PLANNING AMENDMENT

PLOTS 5 & 6, STONEGATE, GEDNEY

H06/1251/98

BUNGALOW ON PLOT 5 CHANGED
TO 'ULLSWATER' DESIGN.

LANGDALE-2

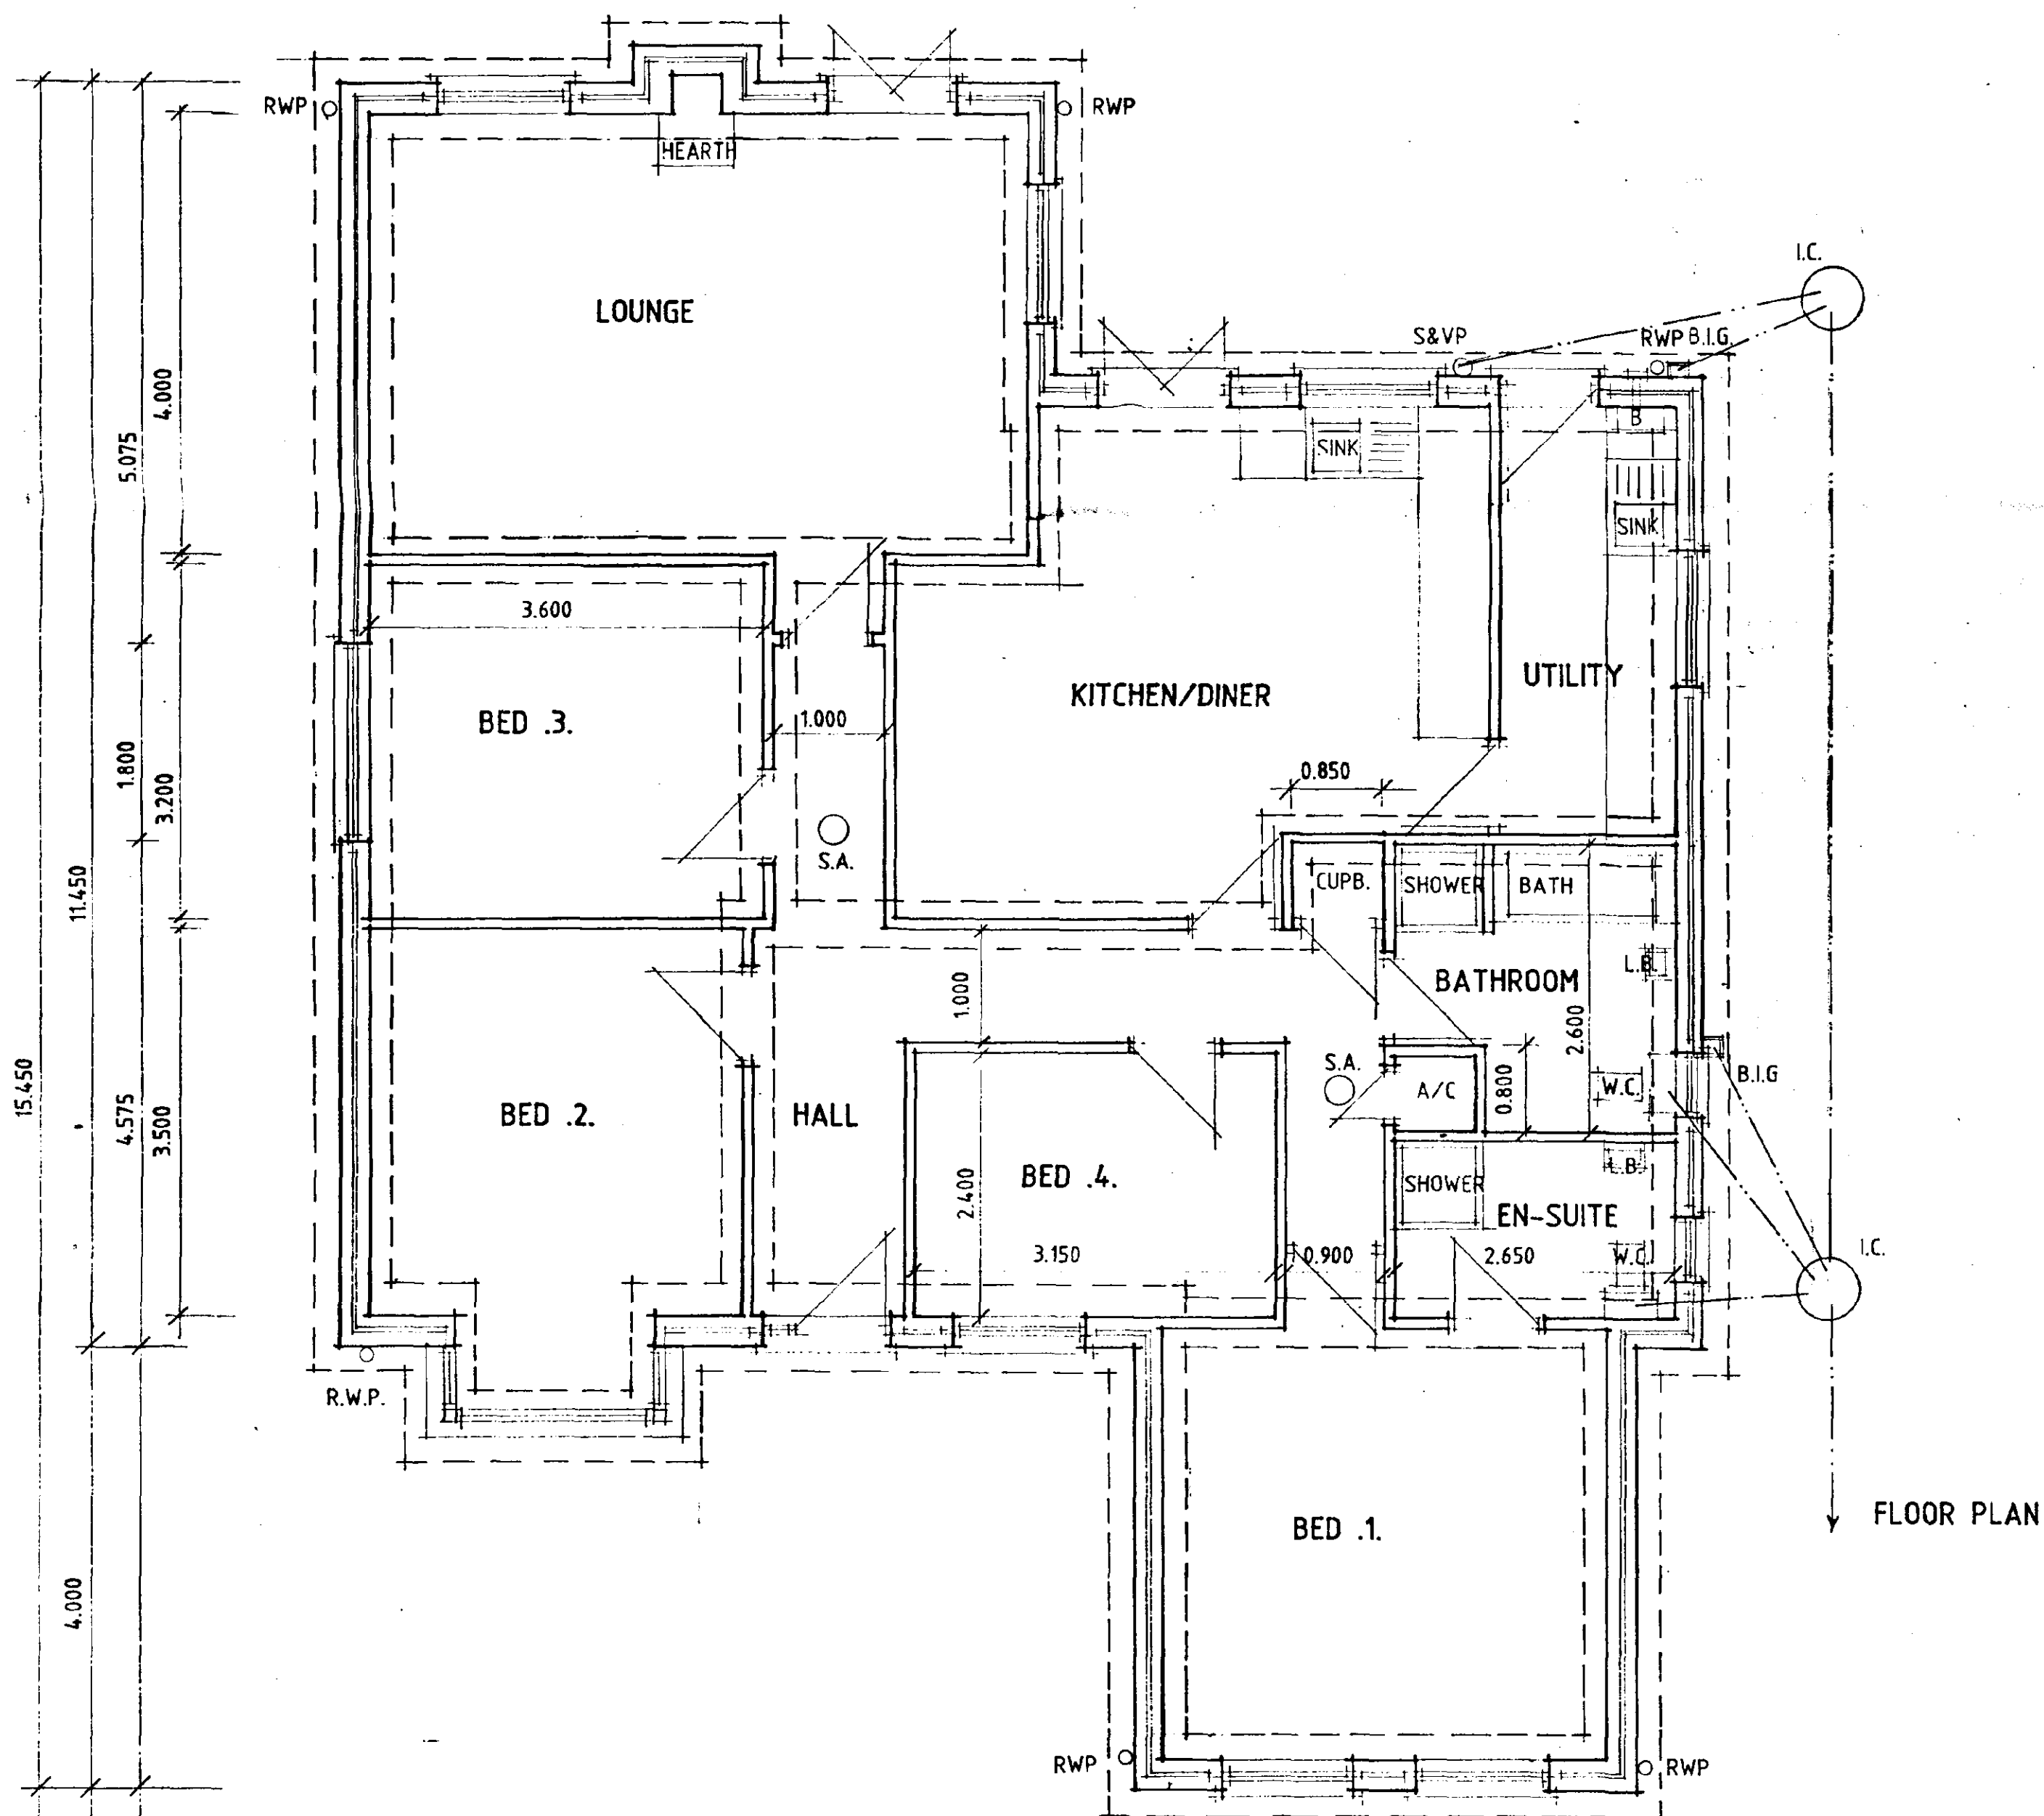
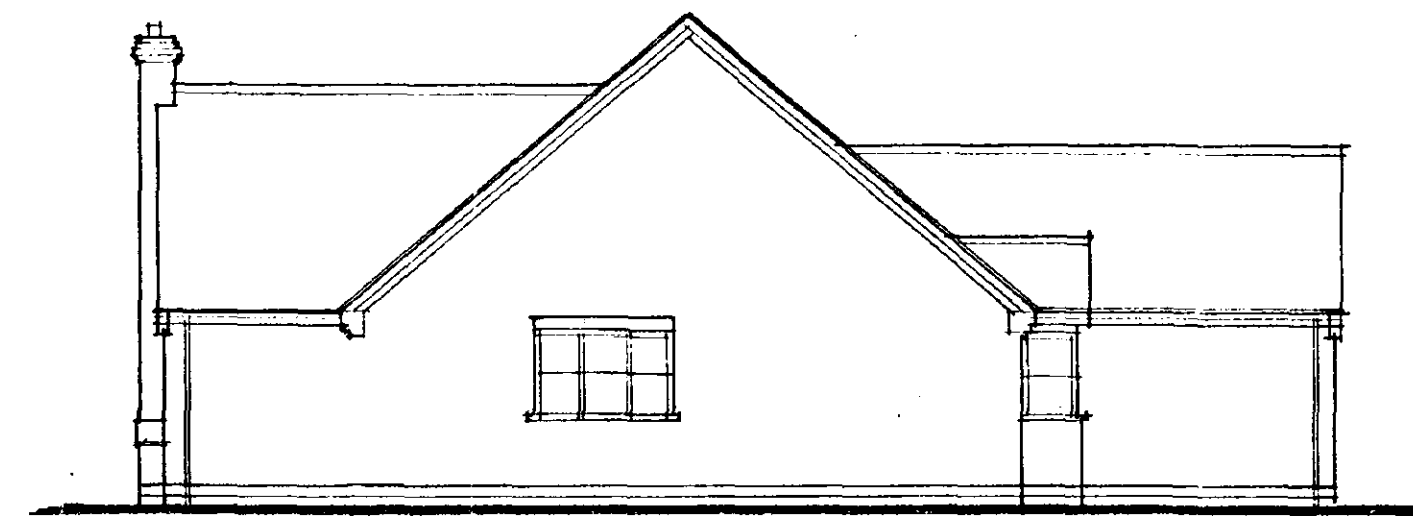
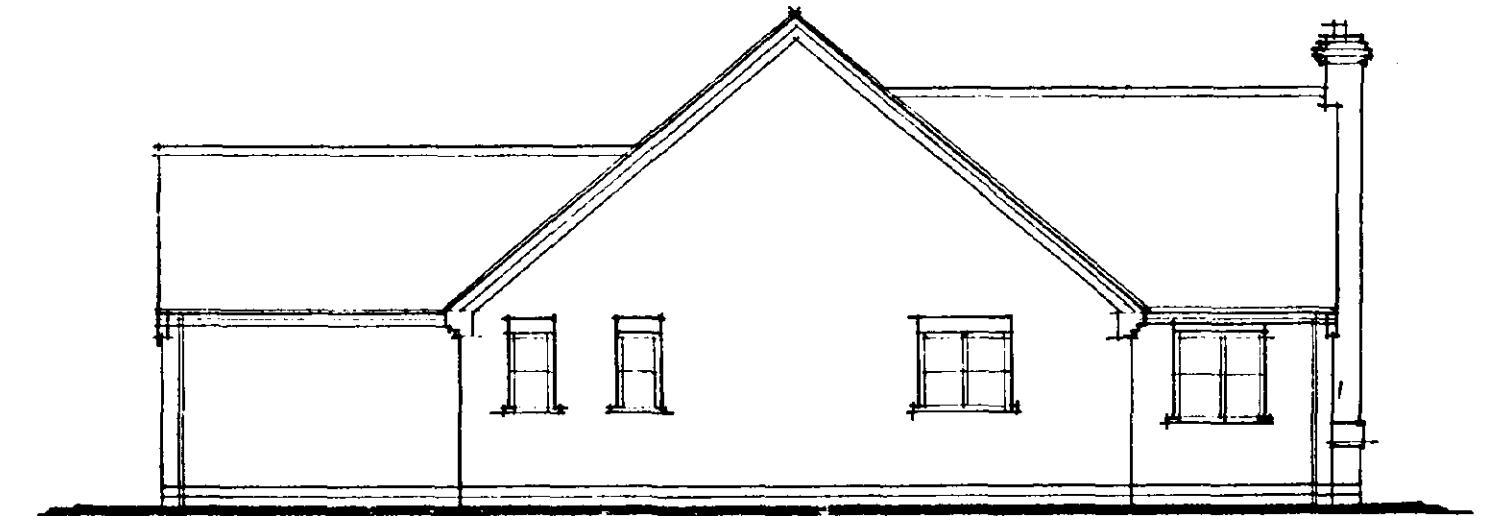
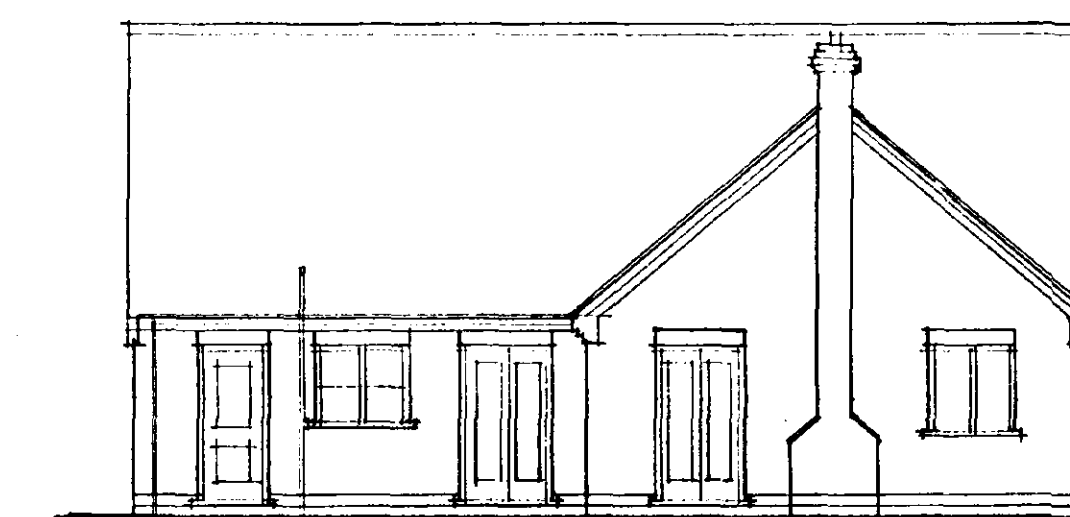
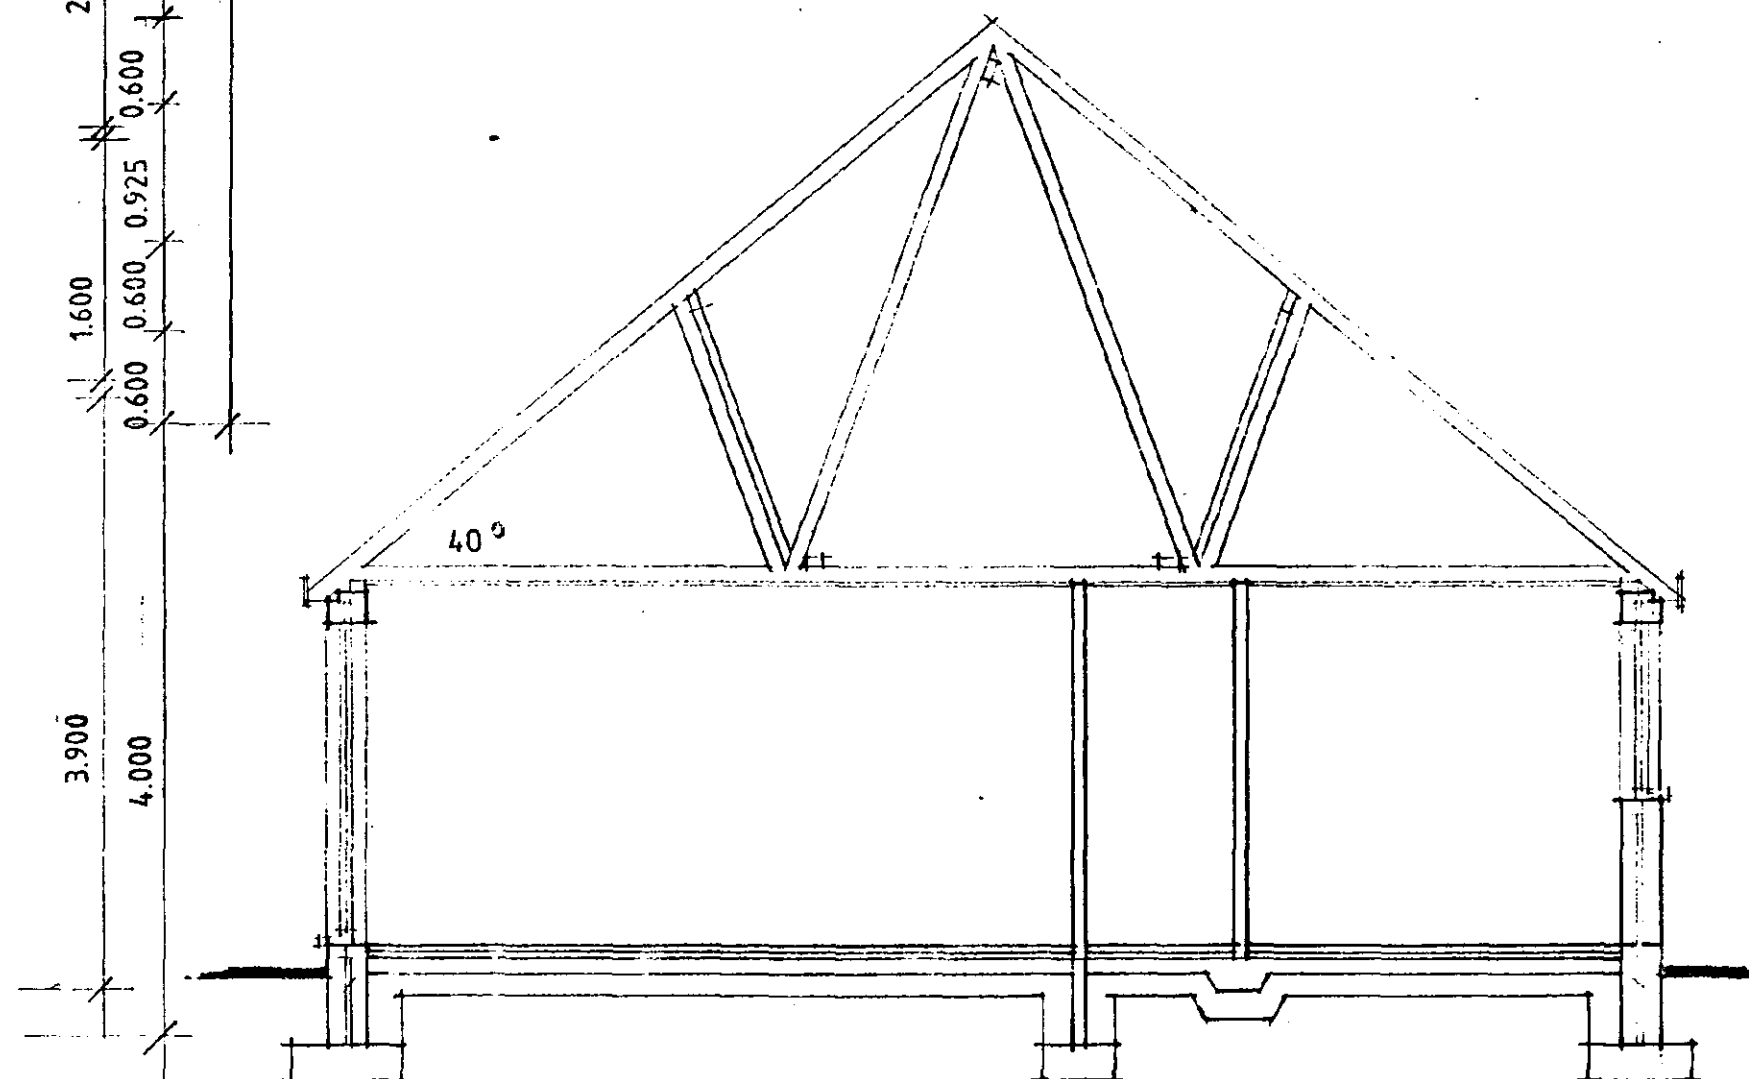
BUNGALOW ON PLOT 6 CHANGED
TO 'LANGDALE 2' DESIGN

AMENDED PLAN

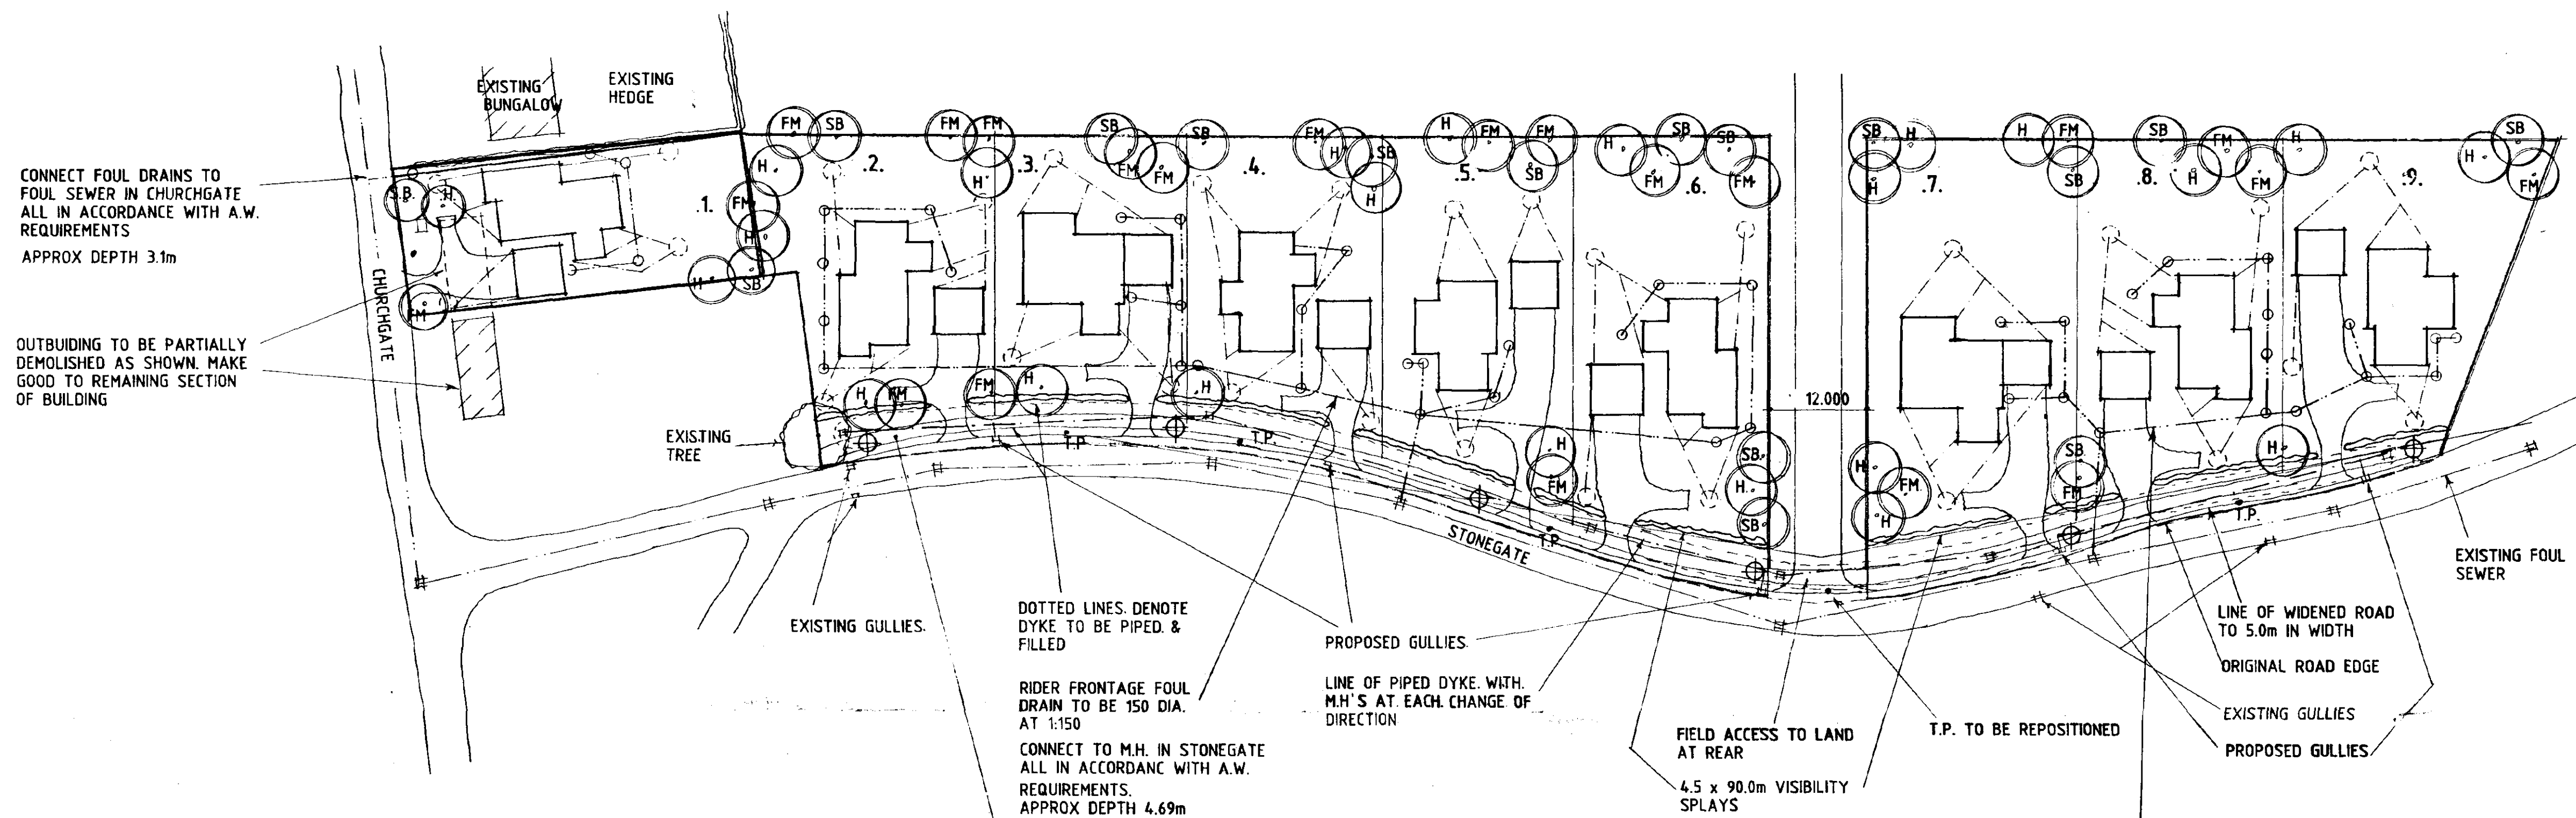
**plots 1-5 removed
grass verge widened
to 2m.**
